FROM: Jodie Wilkes TO: Arun District Council
FAO: Mr D Easton

SUBJECT: A/76/17/L- Application for listed building consent for 5 No. Dwellings.

Avenals Farm, Water Lane, Angmering, West Sussex, BN16 4EP

PROPOSED ROOF PLAN & SHED DRAWING
SCALE 1:100 AT A3

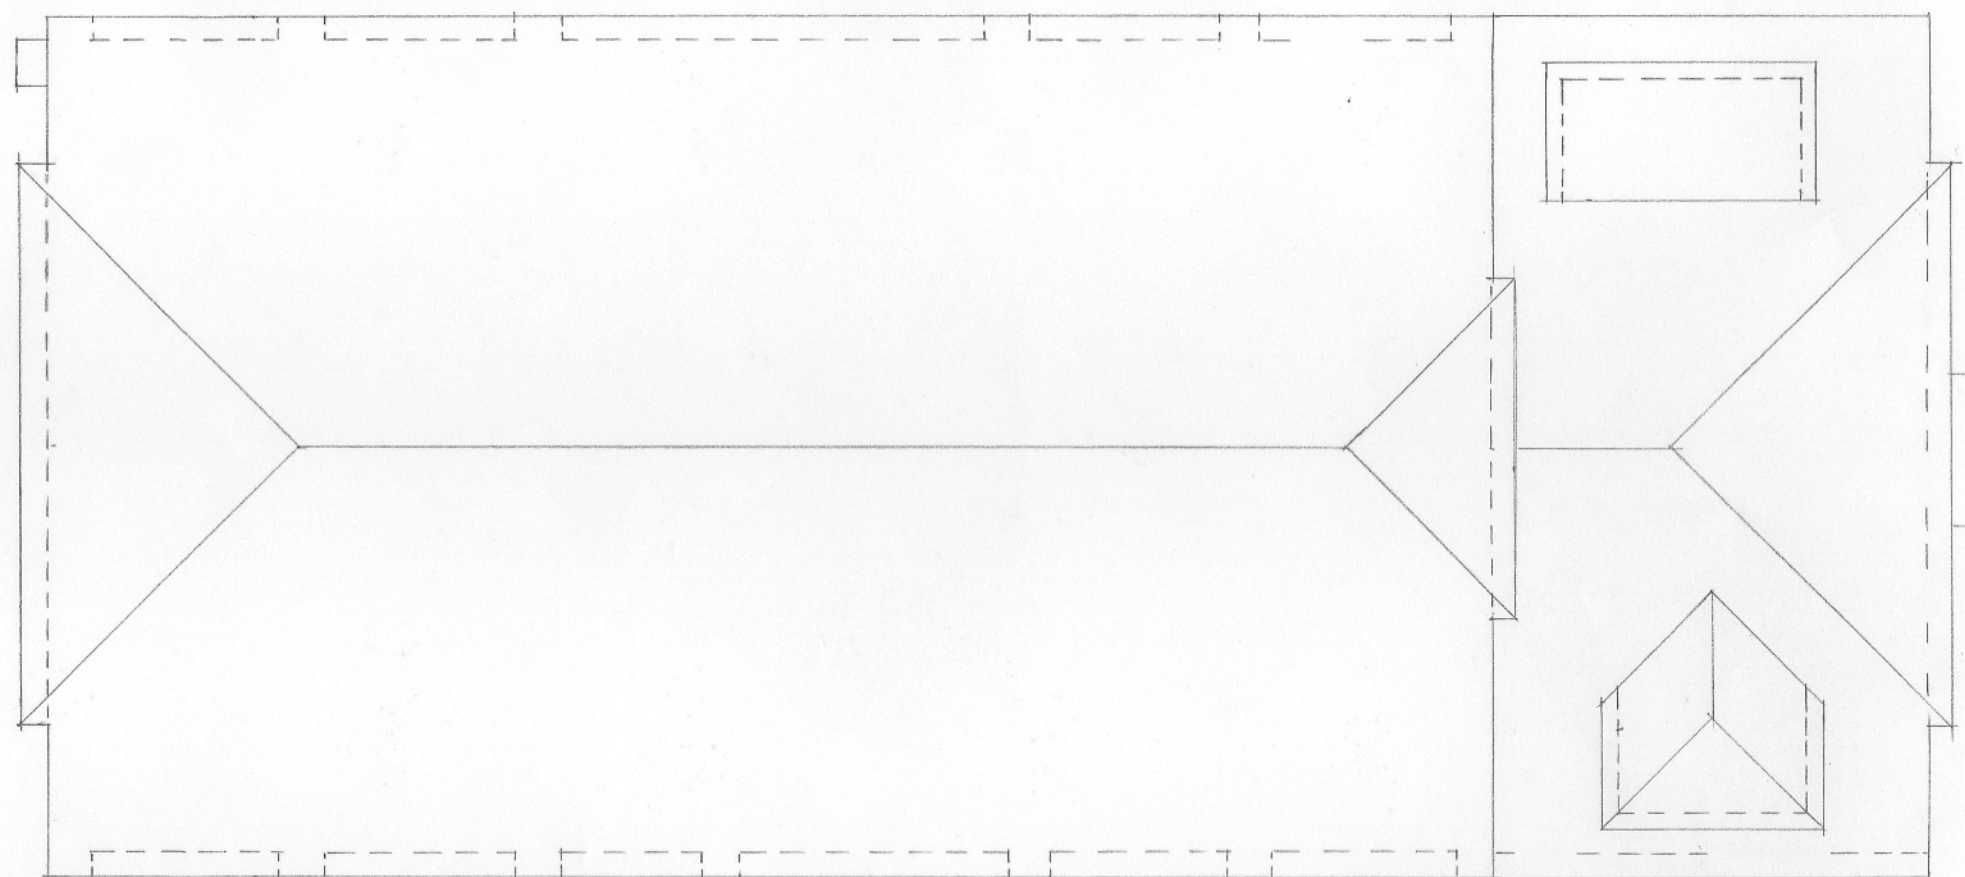
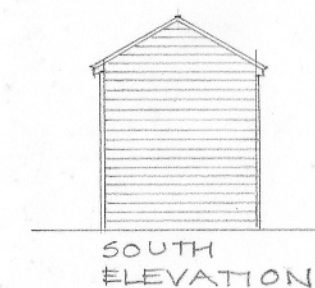
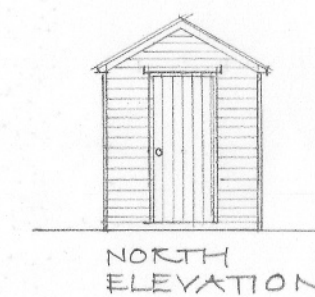
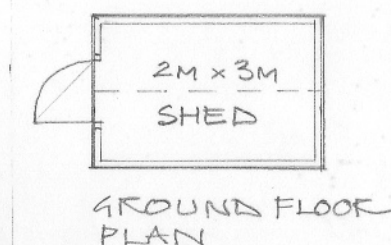
measure 2.4m x 4.8m in order to suitably accommodate an average size vehicle. The LHA also support the proposals to include a shed building which may be utilised as secure covered cycle parking for the new dwelling.

No part of the development shall be first occupied until covered and secure cycle parking spaces have been provided in accordance with plans and details submitted to and approved by the Local Planning Authority.

PROPOSED PARKING PLAN

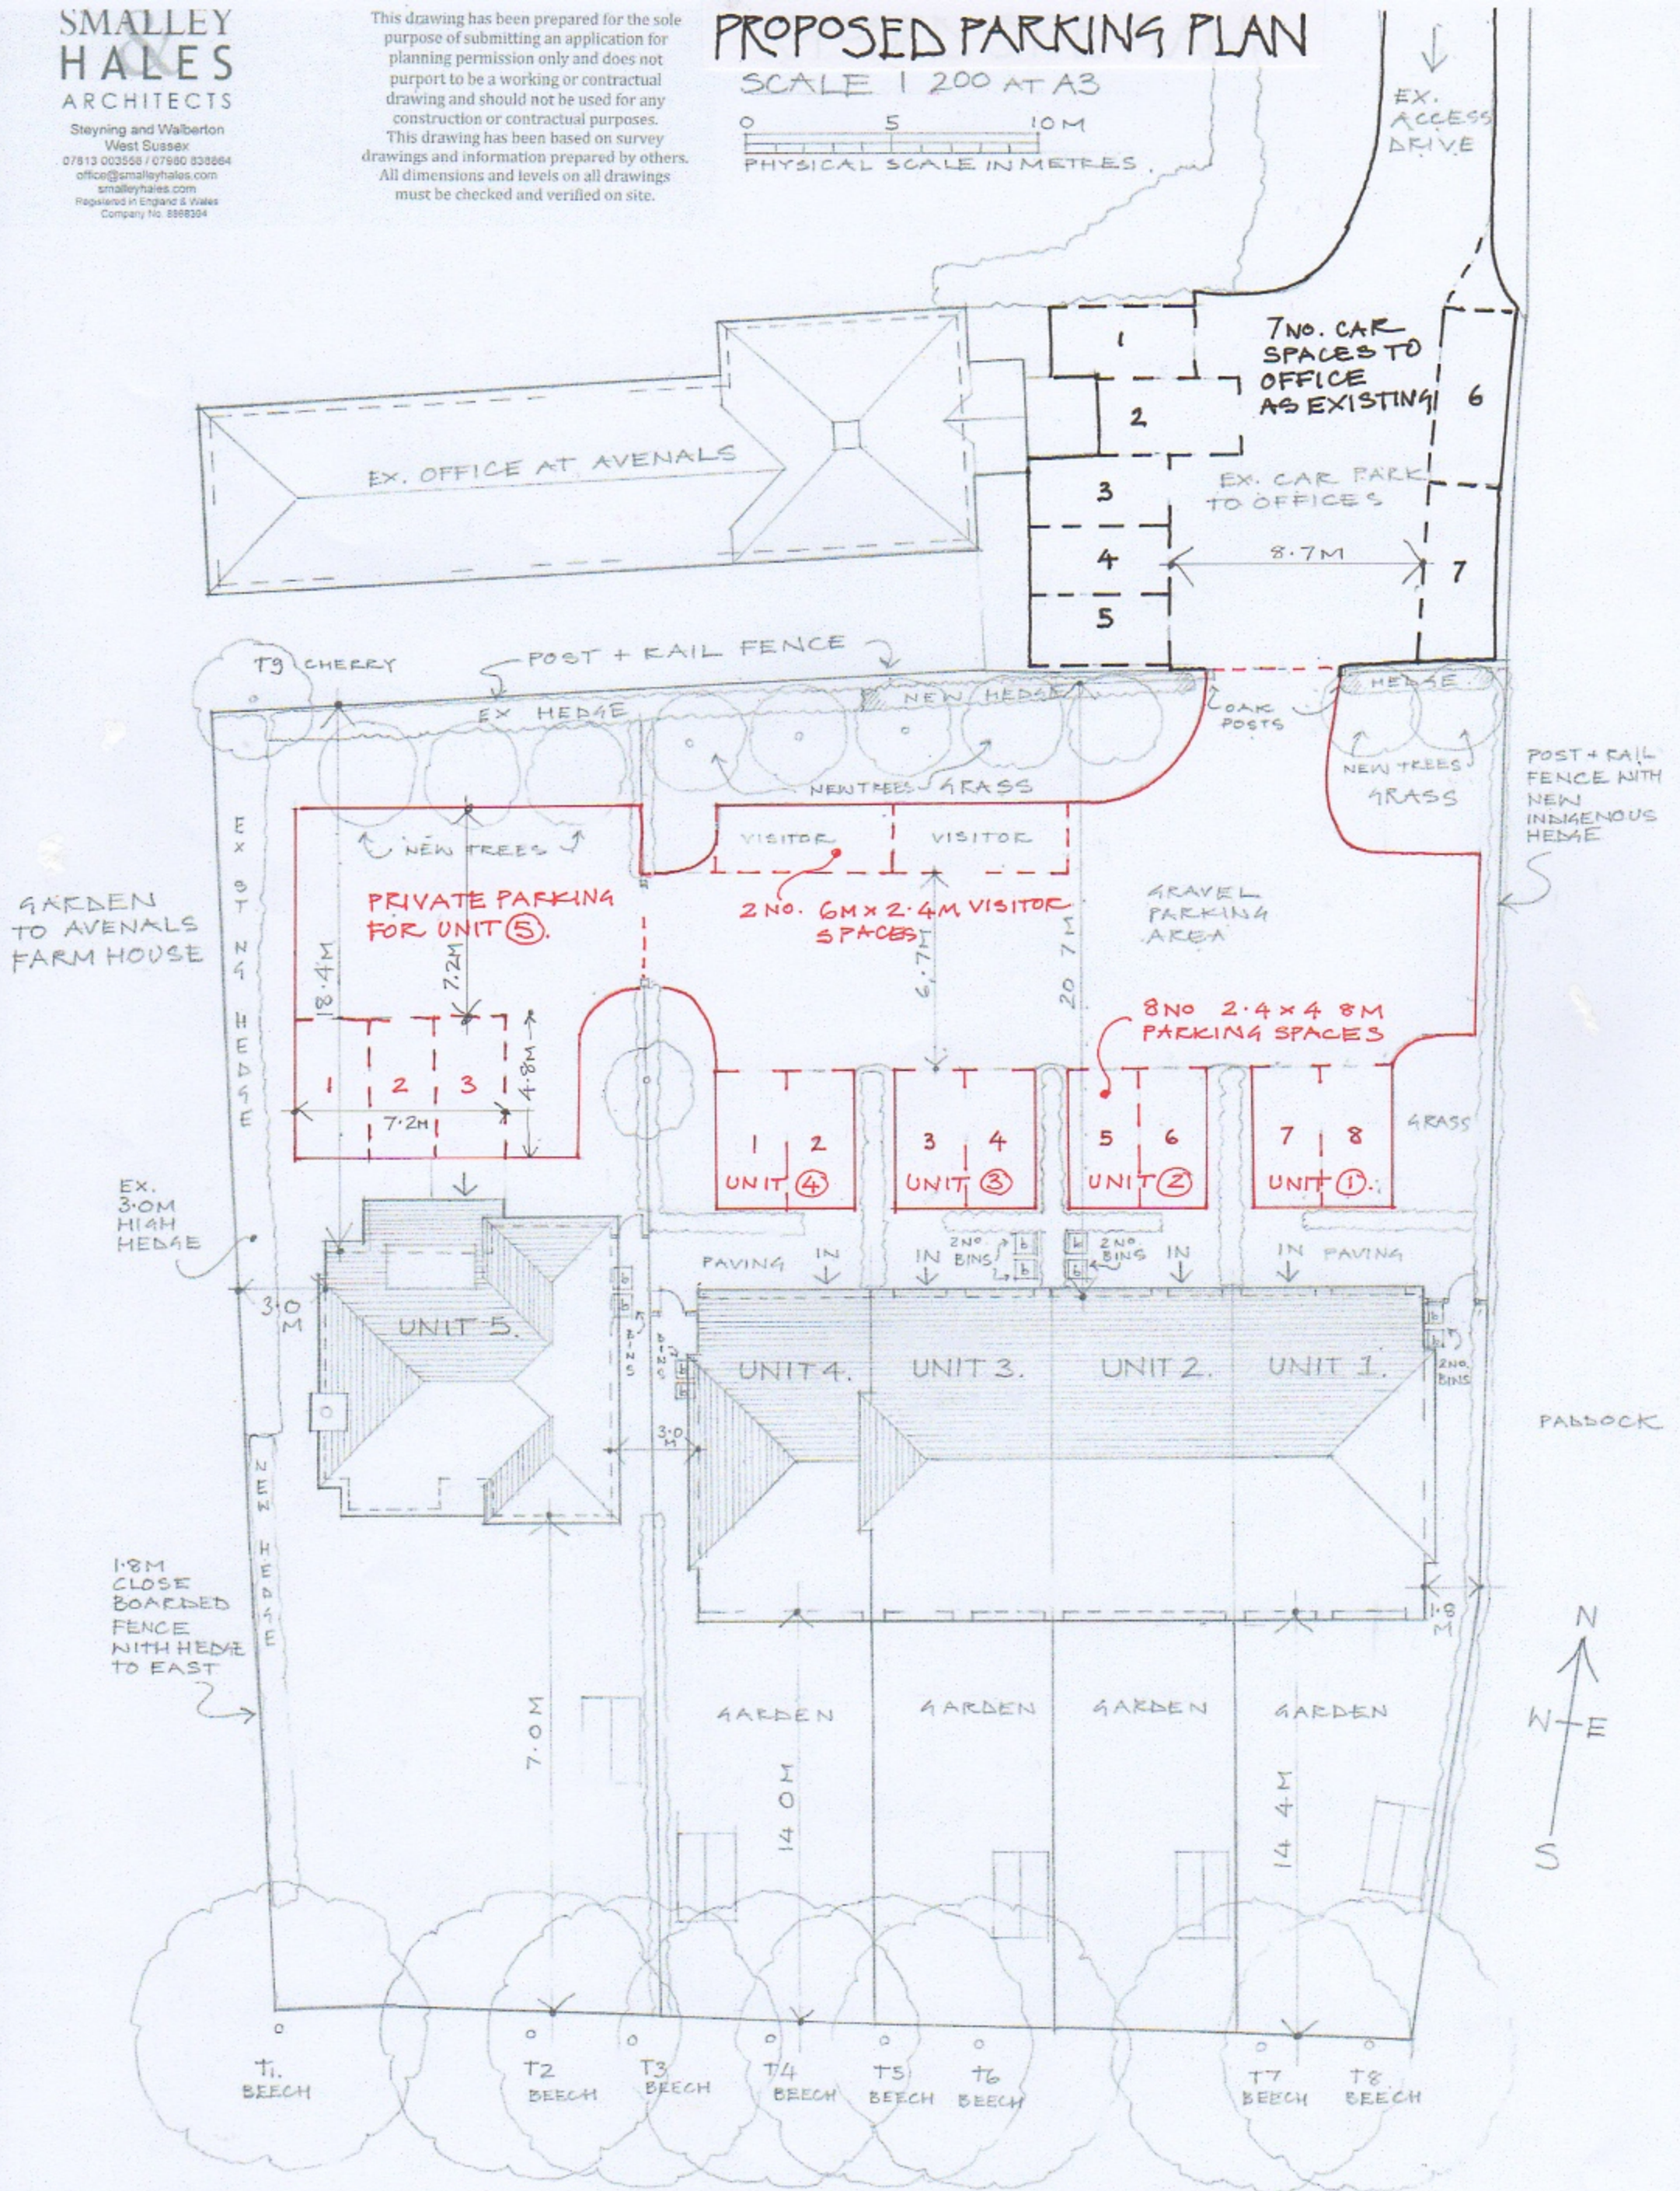
The proposed parking for this development is considered acceptable. The parking allocation is in accordance with the demand from the WSCC PDC (Parking Demand Calculator). From checking this and based on the proposed mix and tenure of the dwellings, the car parking provision is anticipated to satisfy the likely demands. The vehicular parking spaces should

No part of the development shall be first occupied until the vehicle parking and turning spaces have been constructed in accordance with the approved plan. With spaces measuring 2.4m x 4.8m each. These spaces shall thereafter be retained for their designated use.
